DECISION DELEGATED TO HEAD OF PLANNING

Application No: H02-0266-24 **Applicant:** Mr & Mrs C Newman

Proposal: Erection of single storey detached dwelling with integral garaging and additional parking provision for existing dwelling (No. 1A Peterborough Road)

Location: Rear Of 1a Peterborough Road Crowland Peterborough

Cross - Section at narrowest distance between proposed bungalow and side boundary

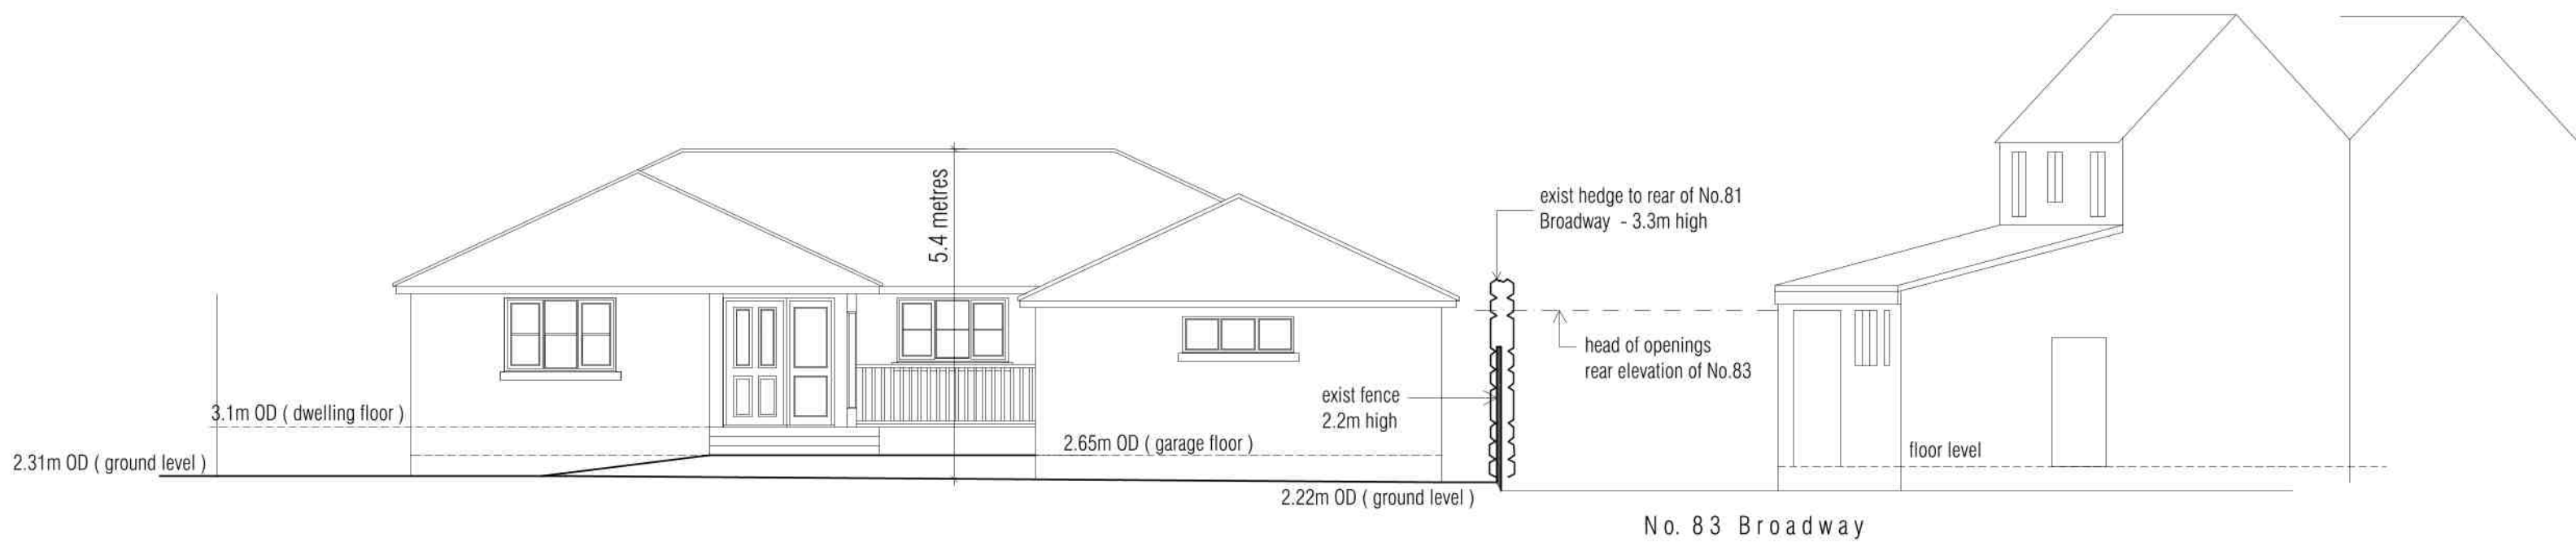
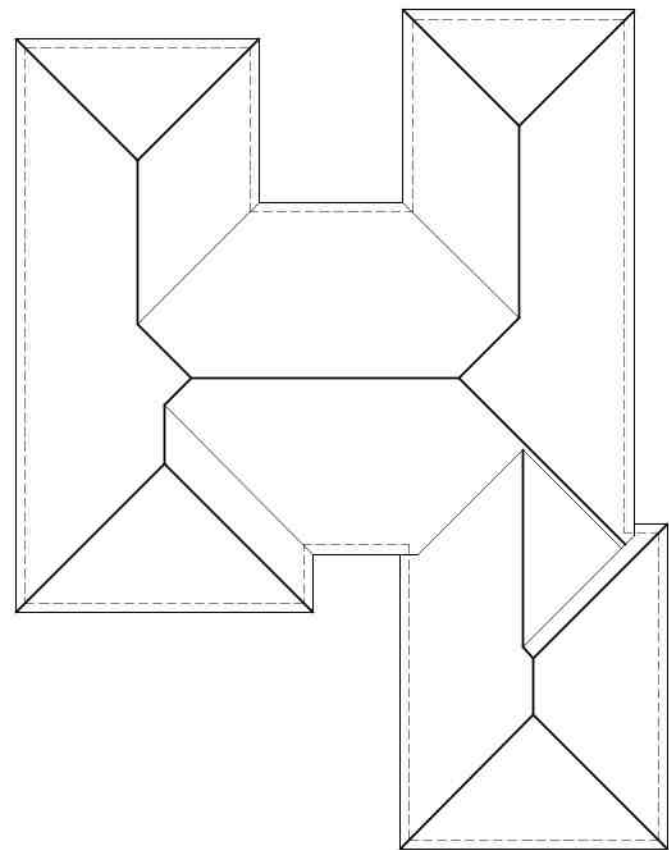
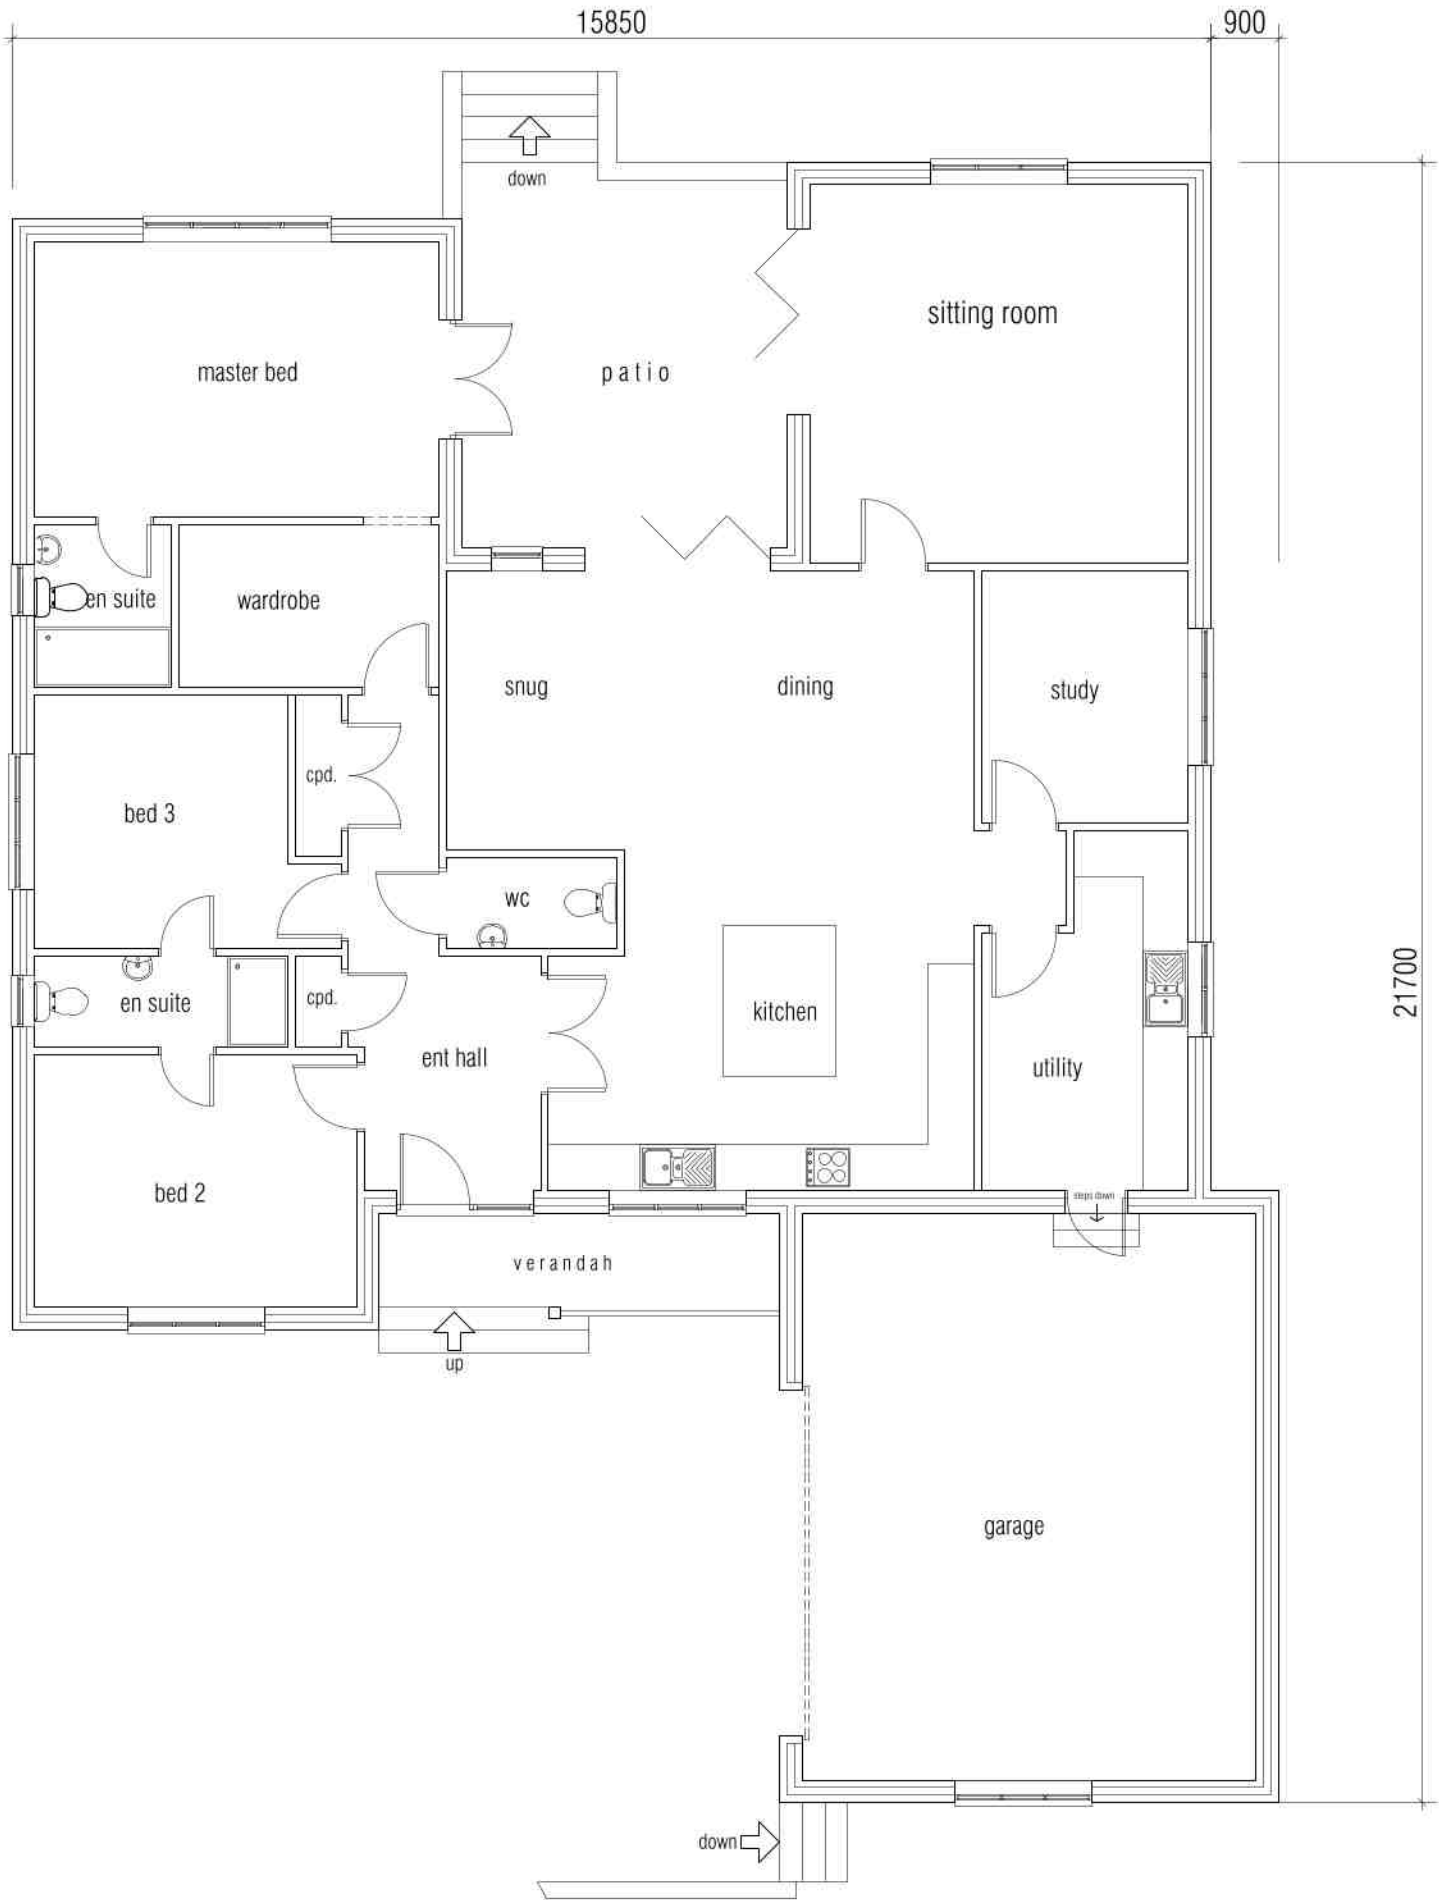
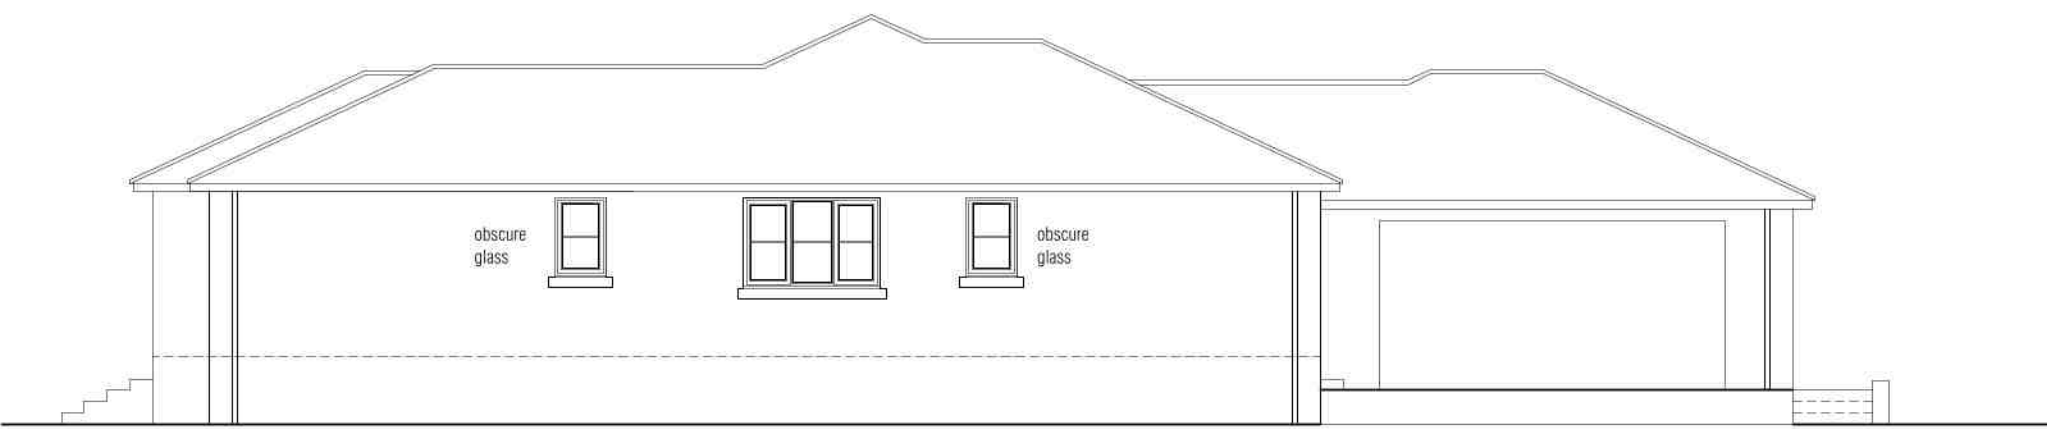
To successfully address flood risk the finished floor levels of the dwelling must be raised 1 metre above ground level. The submitted elevational drawings show finished floor levels of 0.79 metres. The Environment Agency has no objections to the proposed finished floor level height of 0.79 metres. There are other dwellings in the vicinity of the site that also have raised finished floor levels to address flood risk. 85 Broadway approved under reference H02-0187-18 has finished floor levels 500mm above ground level.

There is considered to be a material overlooking impact from the proposed utility room on the northern elevation facing 81 and 83 Broadway. The proposed finished floor levels are currently set at 0.79 metres above ground level. The proposed utility window is located partially above the 2.2 metre high boundary fence and would directly face the rear elevation extension windows of 83 Broadway approved under H02-0525-22. The overlooked windows serve a wc, utility and a dining room. There is no fenestration currently facing these windows. Therefore, there is a new, material overlooking impact on 83 Broadway.

The study window on the northern side elevation of the proposed dwelling faces 81 Broadway. The boundary with 81 Broadway is bordered by a 3.3 metre high hedge. This hedging has restricts views into the rear of the site and is considered to remove a potential overlooking impact from the study

Following conversations with the agent, to address overlooking from the utility window, the applicant would accept a condition to make this window obscure glazed. This is considered to remove the material overlooking impact.

To successfully address flood risk the finished floor levels of the dwelling must be raised 1 metre above ground level. The submitted elevational drawings show finished floor levels of 0.79 metres. The proposed finished floor levels disregard the recommendation of the Flood Risk Consultant S M Hemmings who was employed by the applicant, and recommends finished floor levels between 0.9 metres to 1 metre above ground level. However, the Environment Agency has no objection to the proposed finished floor level and have requested a condition that finished floor levels are set at 3.1mAOD with a further 300mm of flood resistant and resilient construction.
